From: Angela Jolliffe [REDACTED]
Sent: 27 January 2017 16:43
To: Hilary Kernohan; David Innes
Cc: Claire Potts
Subject: Redraw Pollards Nursery Site BN/66/16/DOC, BN/52/16/Res (51/16)

Further to my previous emails relating to the Redrow Application for a revised layout, please see below relating to the Reptile habitat.

FOR LANDS PLANNING, BARRIUM - SITE LAYOUT

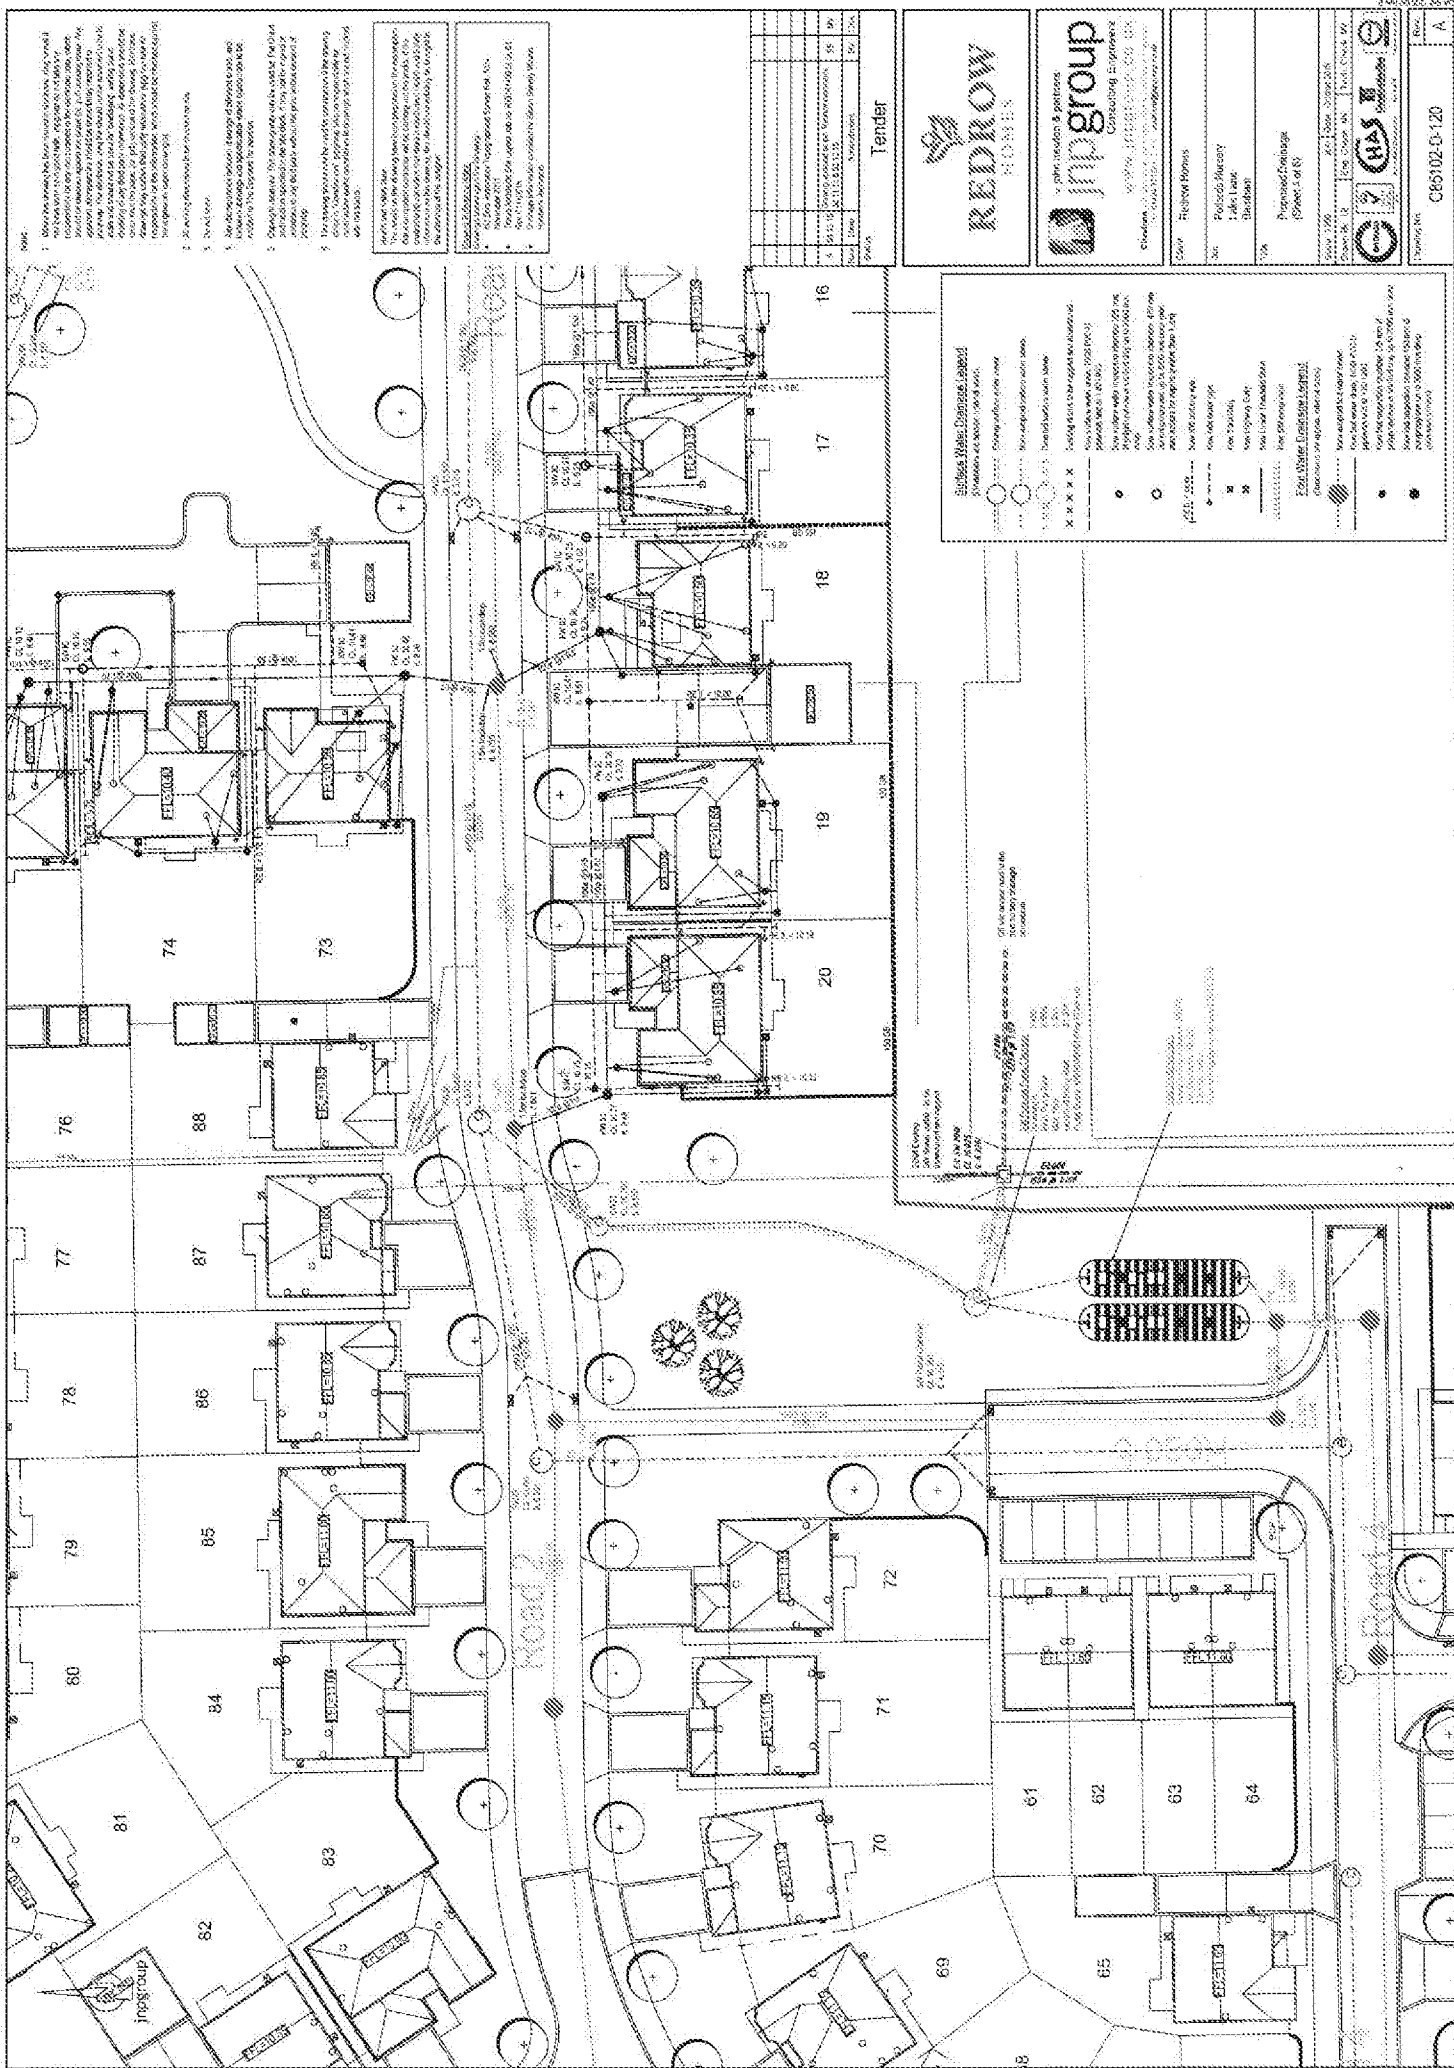
Redrow's plans, to scale, show hedging/greenary extending some 10-14 meters inside the Western boundary of their site. The attached plan shows the reptile habitat to be Retained along the western Boundary (including the substantial reptile habitat along the southern boundary which is to be removed).

Unfortunately, Redrows plan to build 4 houses dissects the Habitat to be retained along the Western Boundary in Figure 3 attached.

In addition the Highgate property they are proposing to build nearest the Western Boundary is 2.5 story. The light spill from this property will encroach on the 10m Bat Commuting and Foraging zone identified in my previous email.

Drawing Number	Rev
717	C

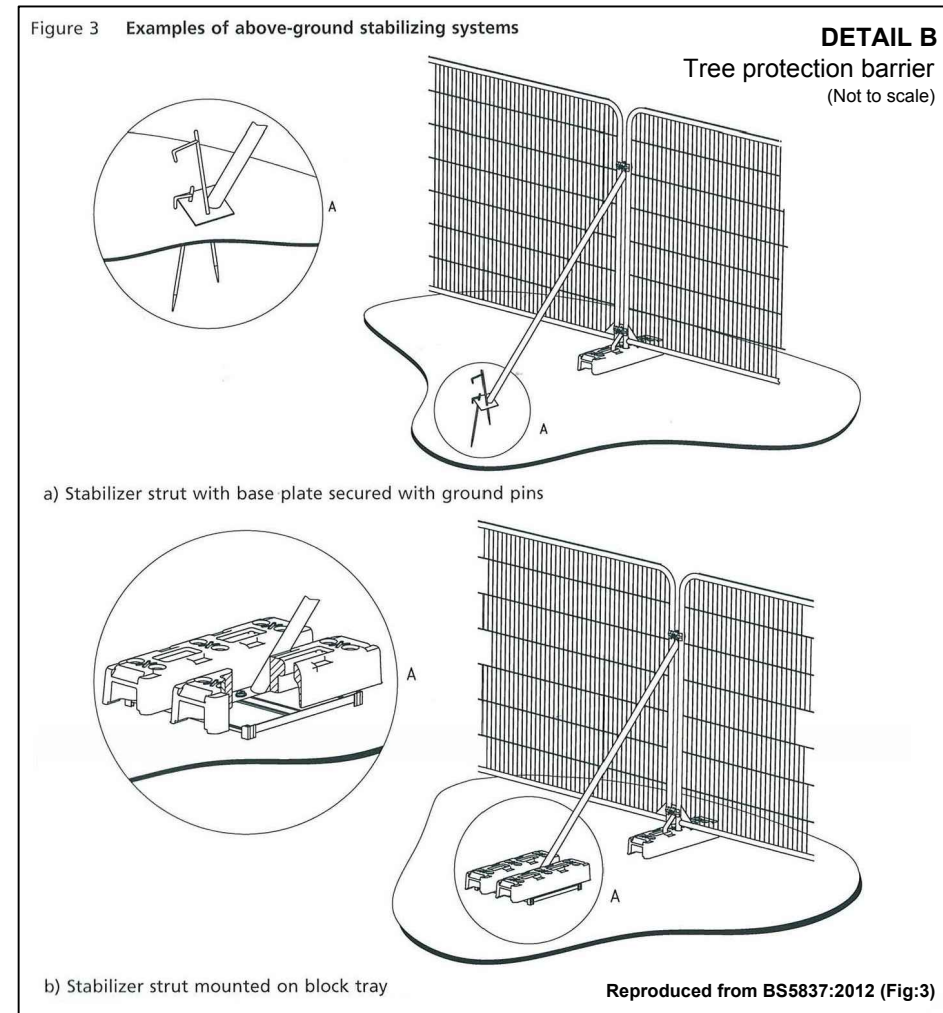
With regards to the Tree T22 on the RPS Drawing 717, dated 15/11/2016, this tree does not appear to be present on the site. I will forward you some current site photos shortly.
